ErSed Reference: 21003-YARDS-LTR-210813

Re: SSD-9522: Kemps Creek Warehouse, Logistics and Industrial Facilities Hub (the Yards)

Changes between CO13362.02.-EW201 and CO13362.02.-C201B

EROSION AND SEDIMENT CONTROL PLAN - STAGE 1  
SCALE 1:1500

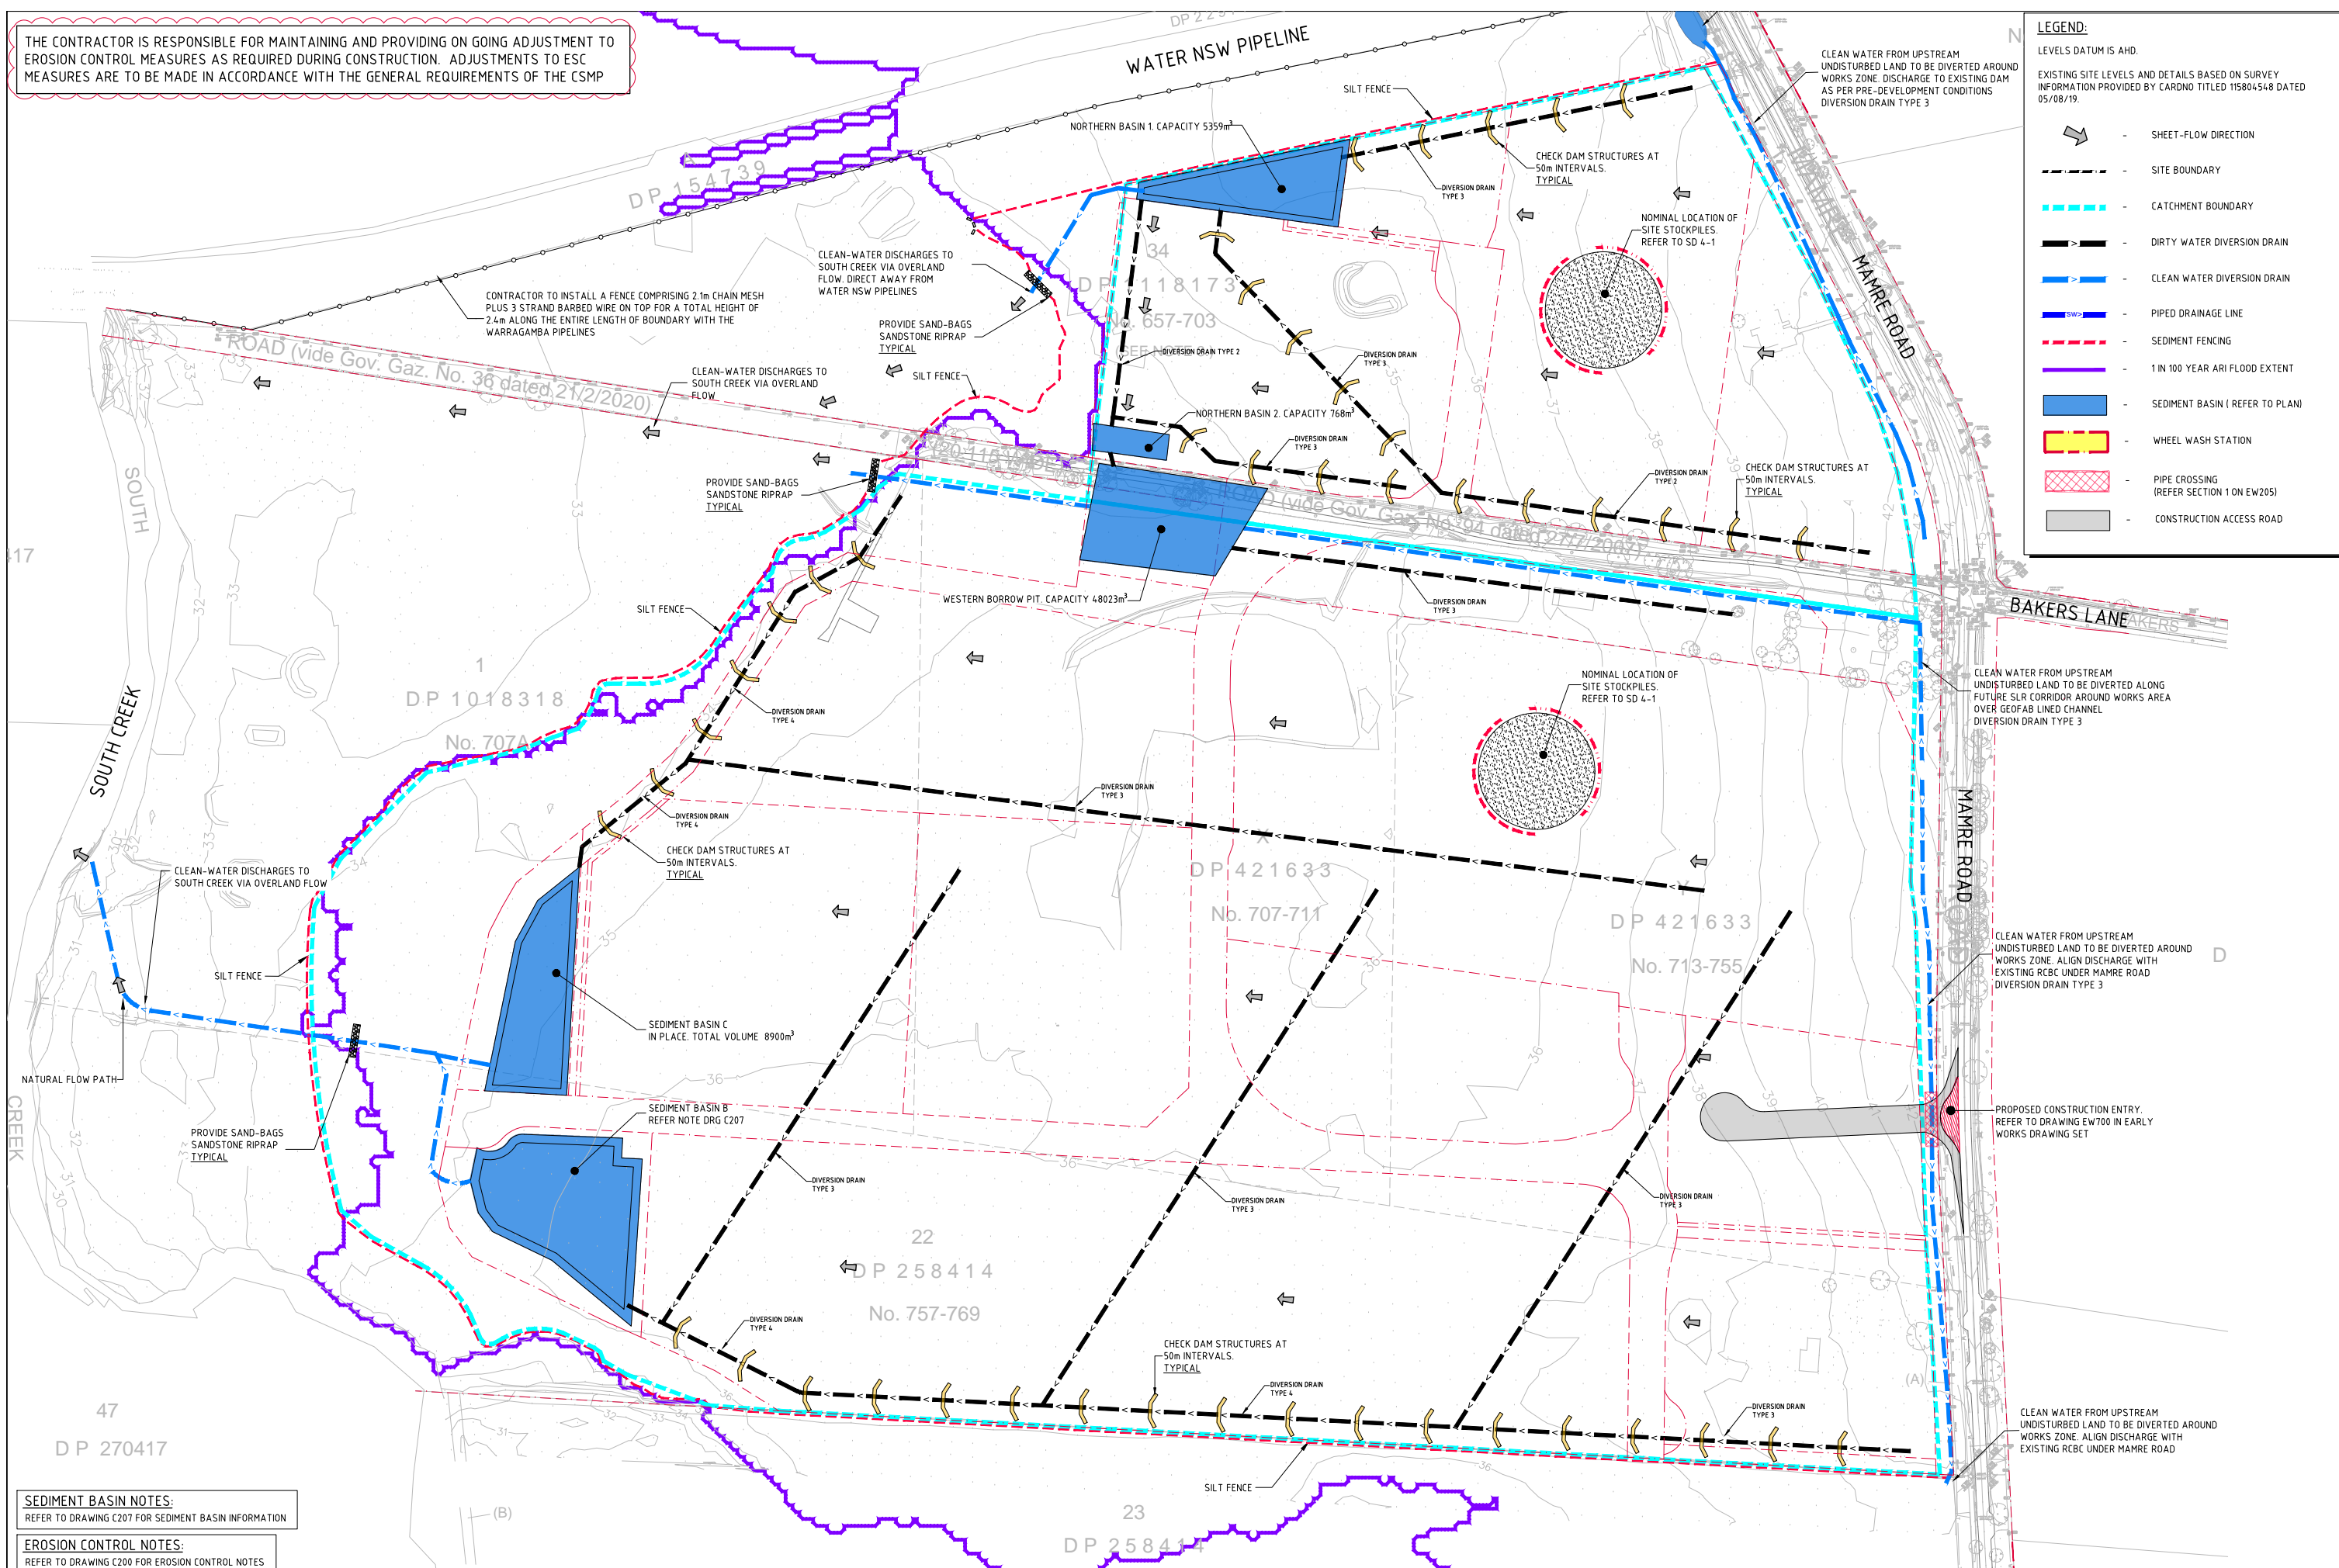
1. EW201 provides a single sediment basin for Precinct 3 (Basin A). This basin is shown to overflow essentially westward along the development boundary and offset from the WNSW Pipeline.

2. EW201 provides a single sediment basin for Precinct 3 (Basin A with volume required of 3797m³).

At time of constructing Basin A, wet site conditions and existing levels meant that the entirety of Precinct 3 could not be made to report to the single Basin A as indicated in EW201.

C201B provides an outlet from Basin A which is slightly modified to flow to the Southwest. This has been changed due to the current saturated ground conditions west of the basin and to reduce potential for the additional flows to flood and pass to the north and towards the WNSW Pipeline.

Accordingly, a second basin (Basin C) has been constructed in the Southwest corner of Precinct 3 to accommodate that portion of the precinct which could not be made to report to Basin A. The reporting catchment has been indicated as 2.64HA leading to a required volume of calculated required volume for 591m³.

Basin A has been constructed with a confirmed volume 5359m³. This exceeds/complies with the volume indicated within the EW201.

Basin C has been constructed with a confirmed volume of 768m³. This exceeds/complies with the volume indicated in C201B.

An equivalent or greater volume is provided within the sediment basins detailed within C201B as that detailed within EW201. These basins have been sized using the same criteria and in accordance with the approved CEMP.
